Deadline 7 Submission

Fiona Cramb [REDACTED]

Document 9.6.2 Appendix B: Consented SPR Outline Landscape Mitigation overlain with the Sea Link Outline Landscape Mitigation for NGET Substation (Scenario 1)

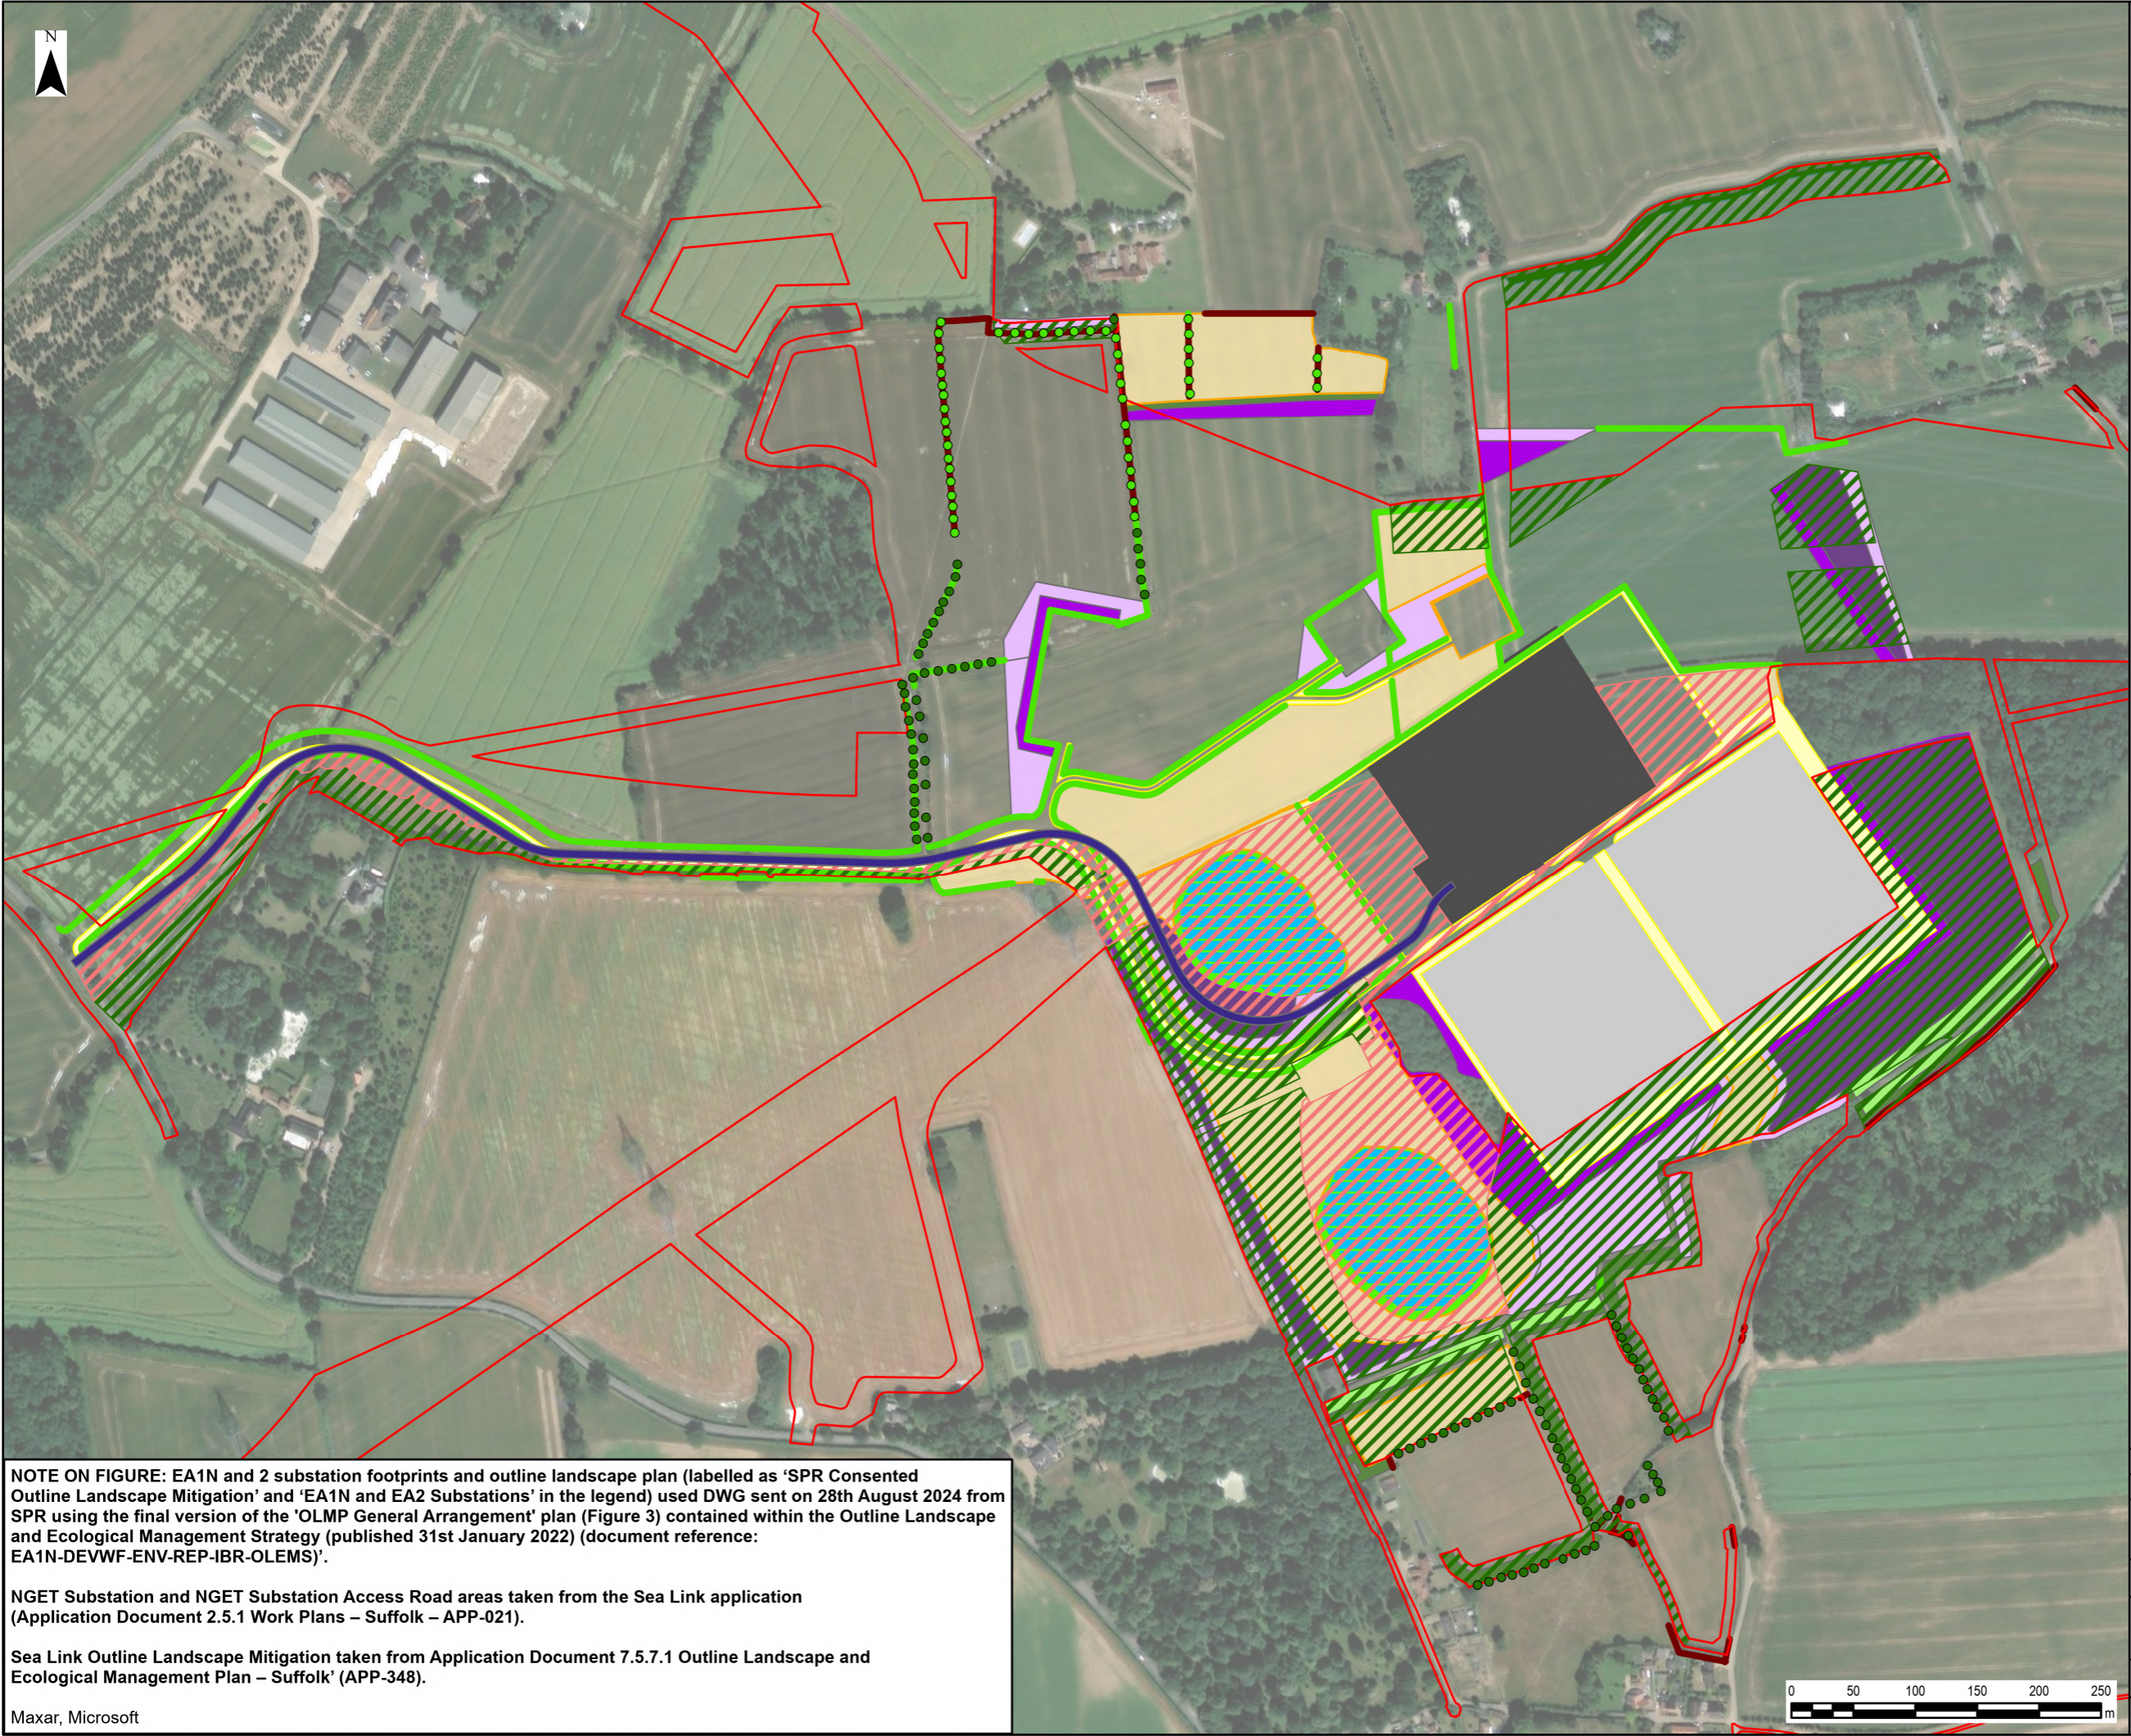
In your letter dated the 21st of April under para 3 Landscape and visual 3.2, you flag changes that have been made to the SPR Landscape mitigation plan and you refer to the planting to the south of High House Farm and say "it has changed from being Native Woodland and Tree planting to just tree planting". You have asked for clarification as to whether the proposed planting has been reduced and whether the visualisation for viewpoint 6A is still accurate. You also ask Sealink to clarify whether the accommodation of Lionlink cables would affect the proposed Landscape planting to the south west of High House Farm as the drawing is not clear.

Looking at the material that we received when discussing the mitigation on the southern side of our boundary, the final design presented by SPR at a November meeting and those presented to you by Sealink now make clear that the mitigation has been downgraded from Native Woodland to just a line of Tree Planting.

I have attached below three landscape design illustrations. The first was the plan that we had agreed with SPR for mitigation on our southern boundary, the second is the design shown at the final SPR meeting I was unable to attend, and the third is the design Sealink have submitted to this planning enquiry. The second is not very clear but the third shows only “tree planting”
